We attach a detailed list of objections to the above planning application which is a revised application of FG/186/18/PL and FG/220/18/PL. The latter application was refused by Arun District Council on the grounds that the new dwelling would have an unacceptable impact on the residential amenity of neighbouring properties, including the host dwelling in terms of loss of light, overbearing impacts and loss of privacy, contrary to policy D DM1 (3) of the Arun Local Plan. The appellant's appeal was dismissed by HM Inspectorate on the grounds of 'the harmful overbearing impact on the occupiers of the host property and harmful loss of privacy to the occupiers of Magalia, contrary to policy D DM1 of the Arun Local Plan.

It seems to us that the new proposal in application FG/141/19/PL makes only minor changes to the proposed property. Our objections remain as follows -

**PROPOSED ROOF PLAN AND
PROPOSED ELEVATIONS
(PROPOSED NEW DWELLING)**

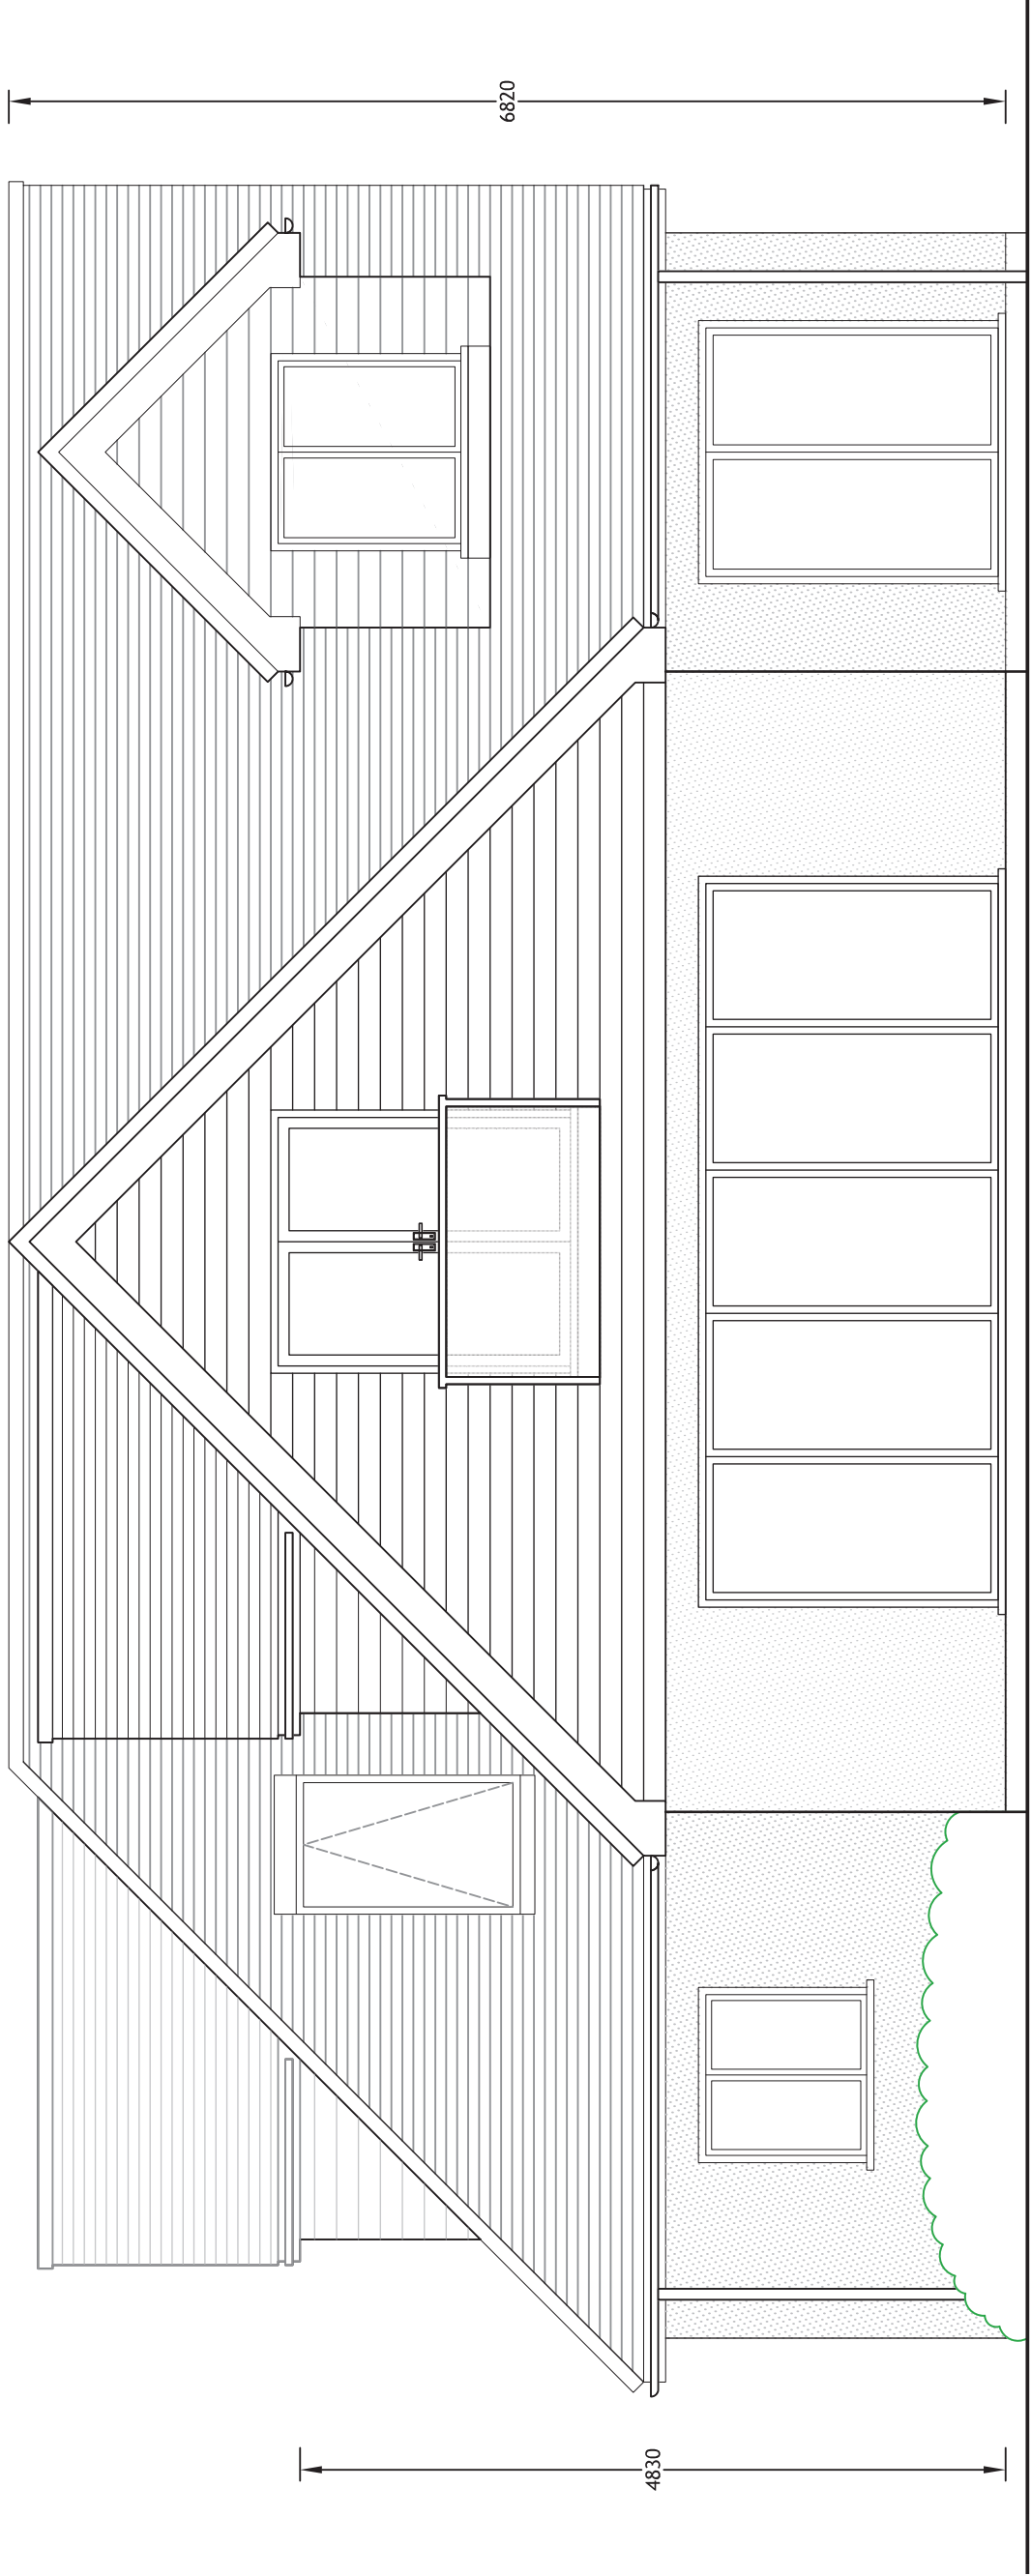
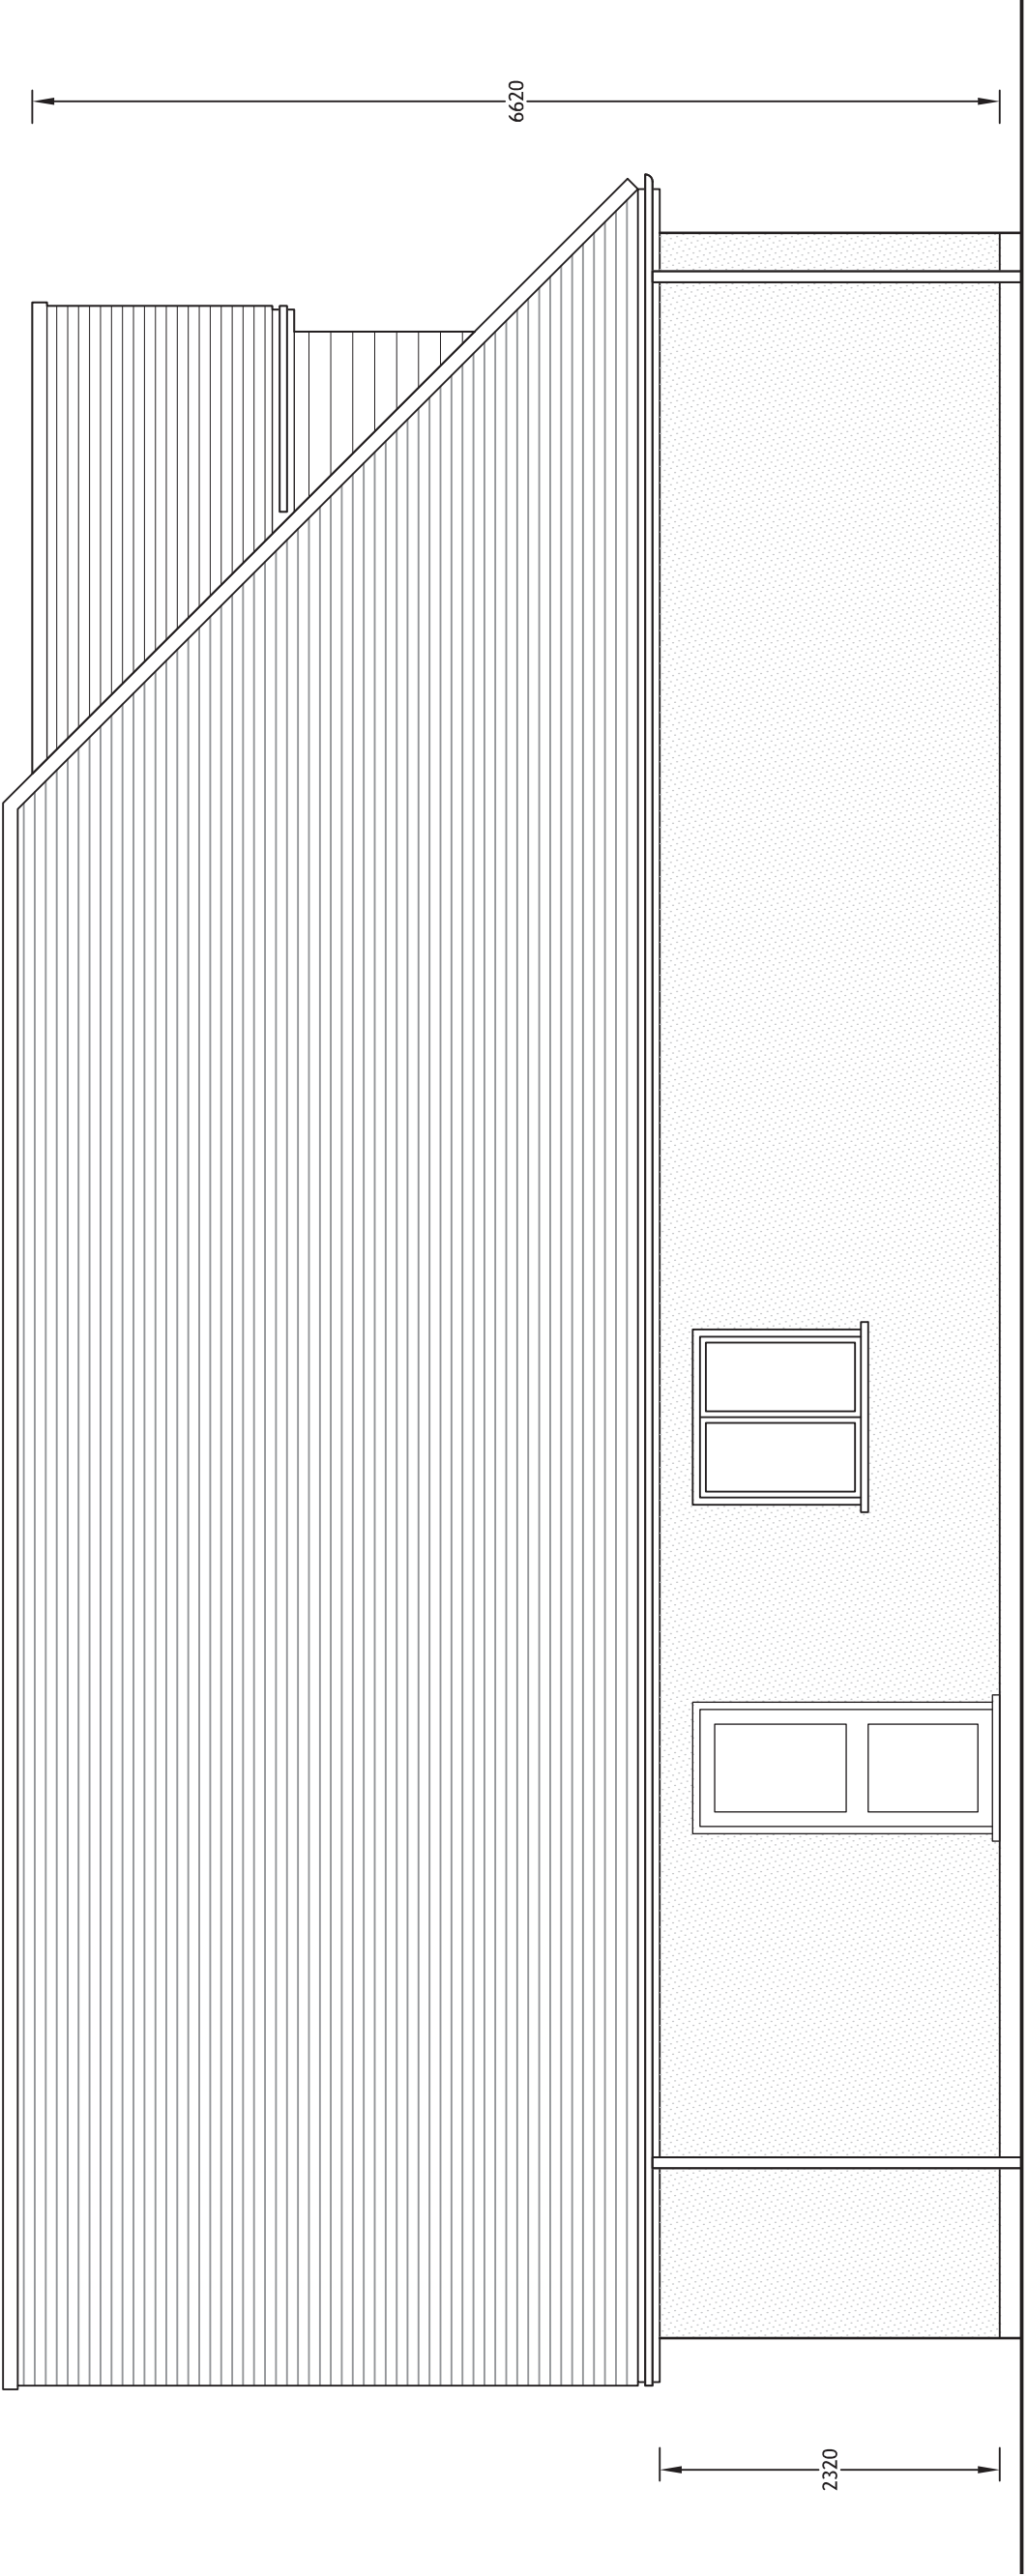
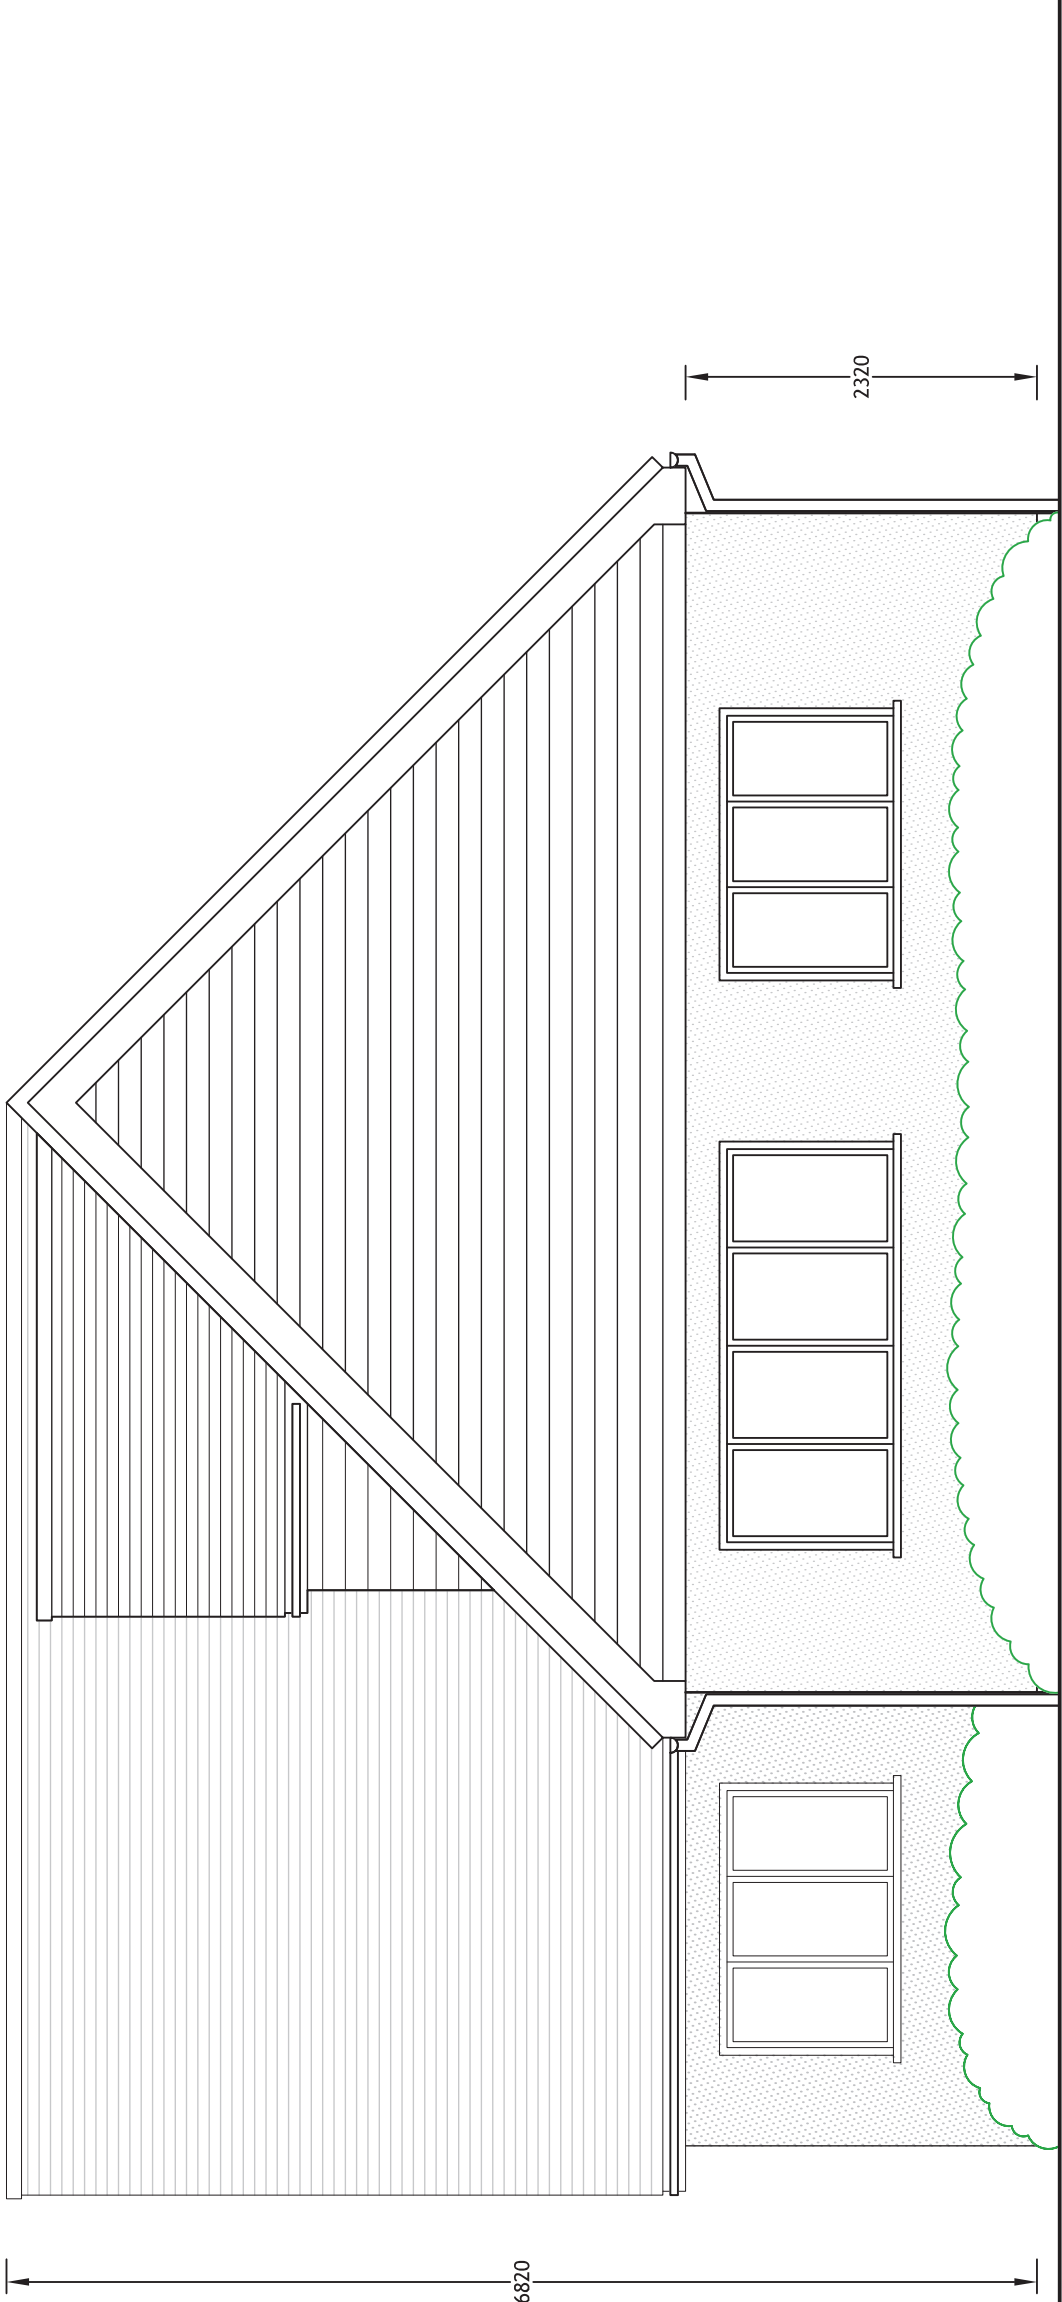
1. Alterations to South facing windows using obscure glass with non-operable windows does not guarantee long term privacy. We strongly suspect that it would only be a matter of time before current or future owners revise the room layout and replace windows with clear openable glass windows.

3. We would contend that notwithstanding the proposed window alterations, the sheer size of the proposed property would dominate the street scene of Tamarisk Way and its surrounds. The Inspectorate drew clear attention to the proposed property's impact on Magalia in particular and was a major reason for the appeal's dismissal.
